**Application Reference:** 2025/0677

**Site Address:** 71 Welland Crescent, Elsecar, Barnsley, S74 8AE

**Introduction:** Erection of front porch extension to dwelling

STATUS	PURPOSE OF ISSUE
M: 07999322120 E: info@slhomedesign.co.uk W: www.slhomedesign.co.uk	
PROJECT	
FRONT PORCH	
TITLE	
PROPOSED PLANS AND ELEVATIONS	
ADDRESS	
71 WELLAND CRESCENT S74 8AE	
DRAWN BY	CHECKED BY
SLH	SH
SCALE (@ A1)	PROJECT NUMBER
1 : 50	2501
DRAWING NUMBER	REV
A301	
DATE	
27-07-2025

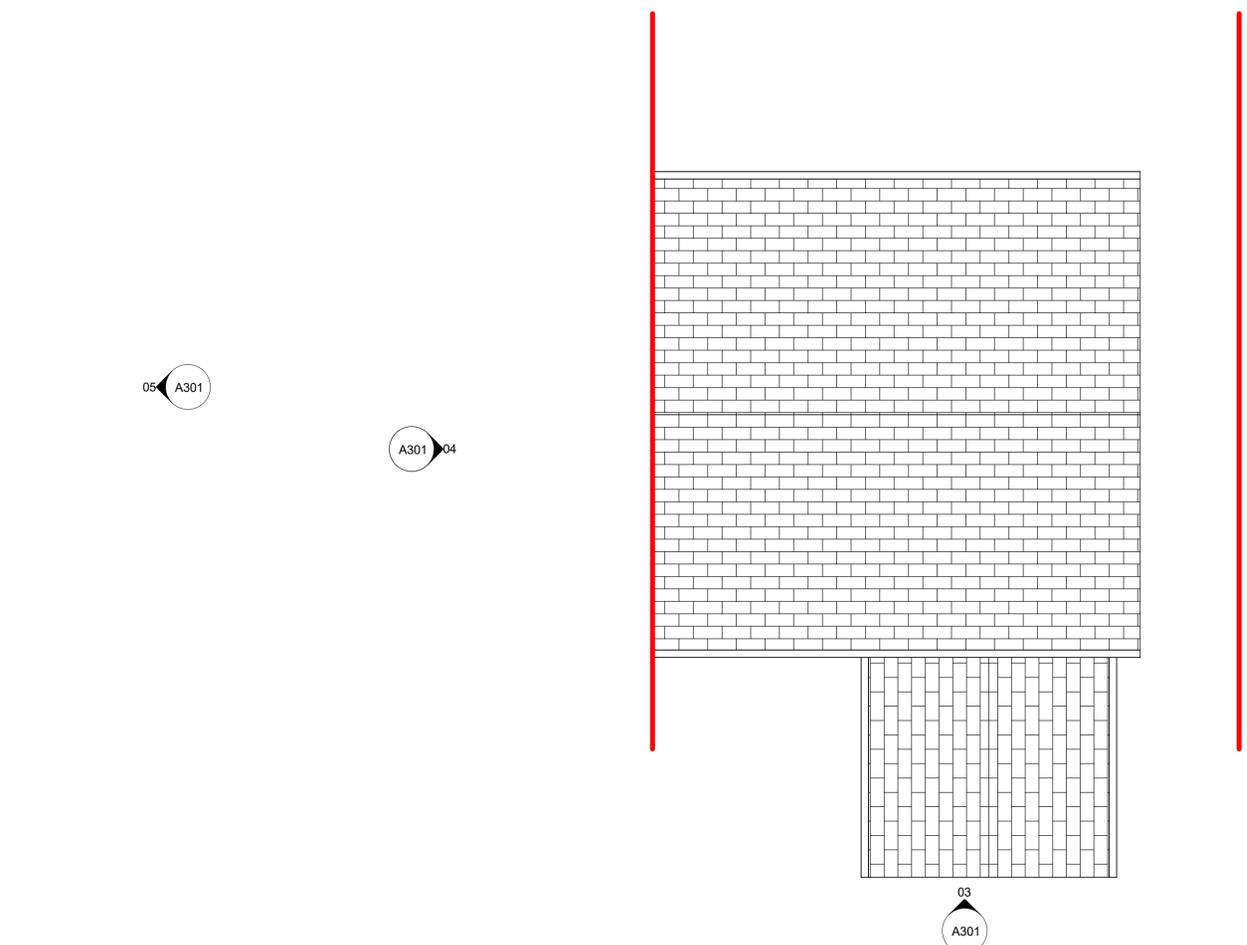
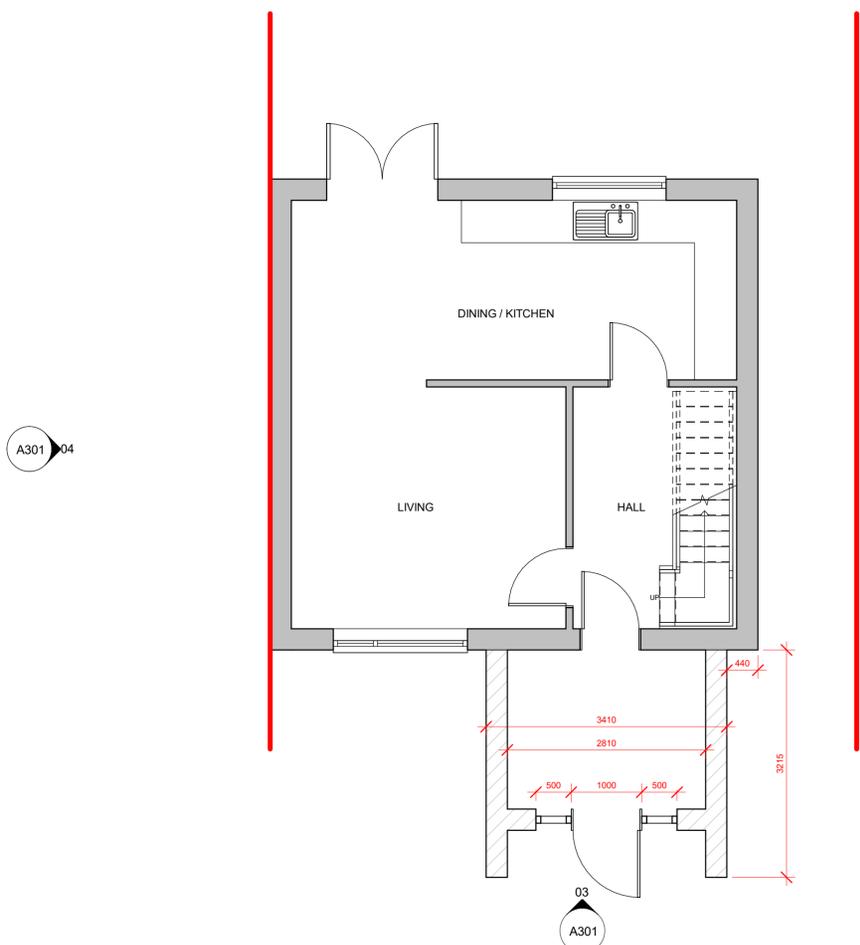
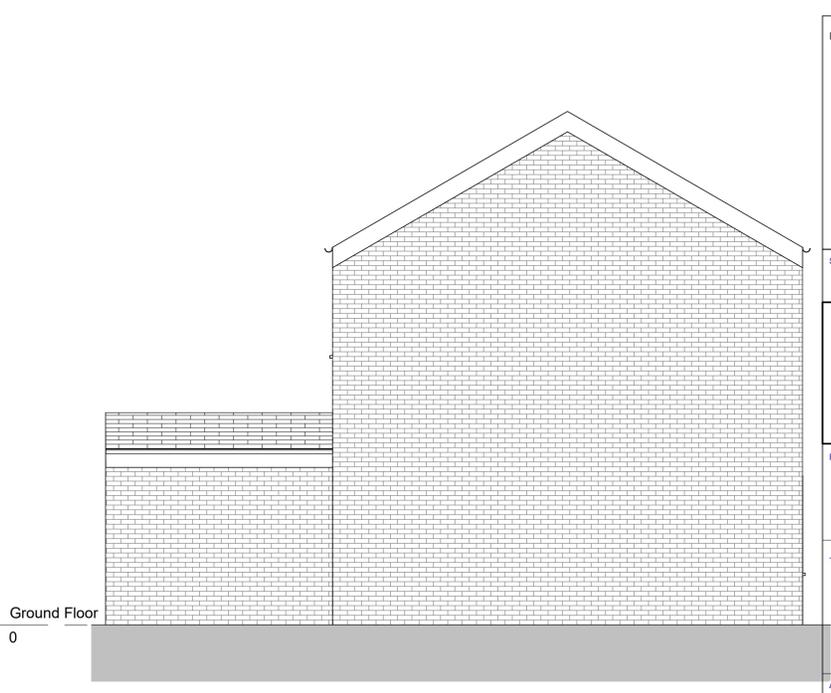
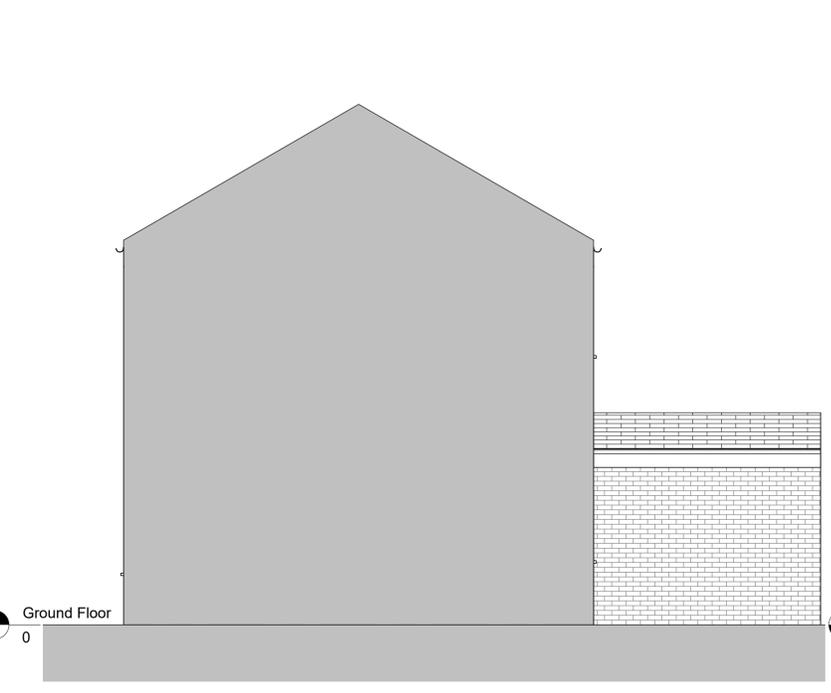
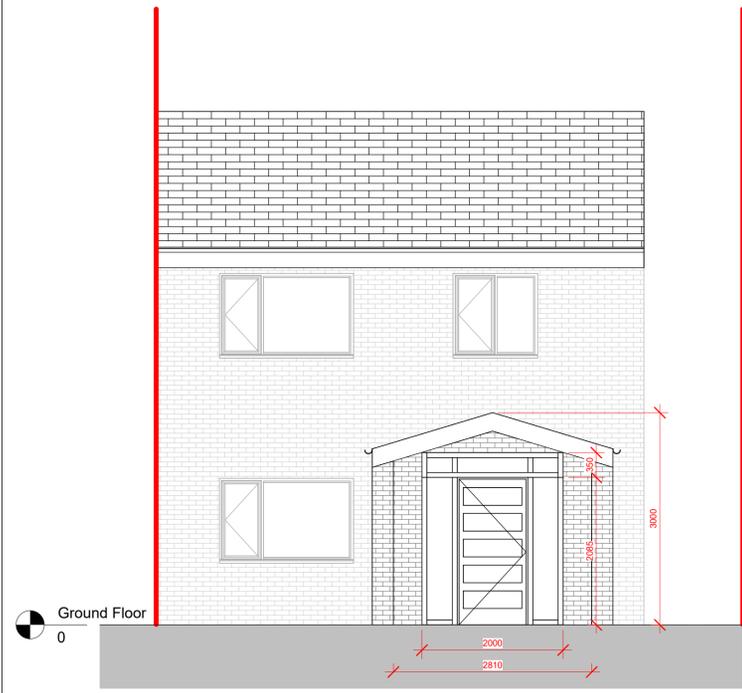
The proposed porch provides a gable form which is beneficial to the proposal and in keeping with the character of the dwelling and the street scene. The proposed projection is relatively large for a porch, however, is considered acceptable given other large front extensions within the street scene. The location of the front door is appropriate and replicant of the position of the existing front door. The use of matching materials is welcomed and allows the proposal to remain in keeping with the character of the dwelling and ensures there is no detrimental impact on the street scene.

It has been necessary to make contact with the agent in order to amend the proposed projection. The original projection was considered too large and would have provided a poor precedent within the street scene and detracted from the character of the dwelling. Amendments were received on 25<sup>th</sup> September 2025, reducing the projection.
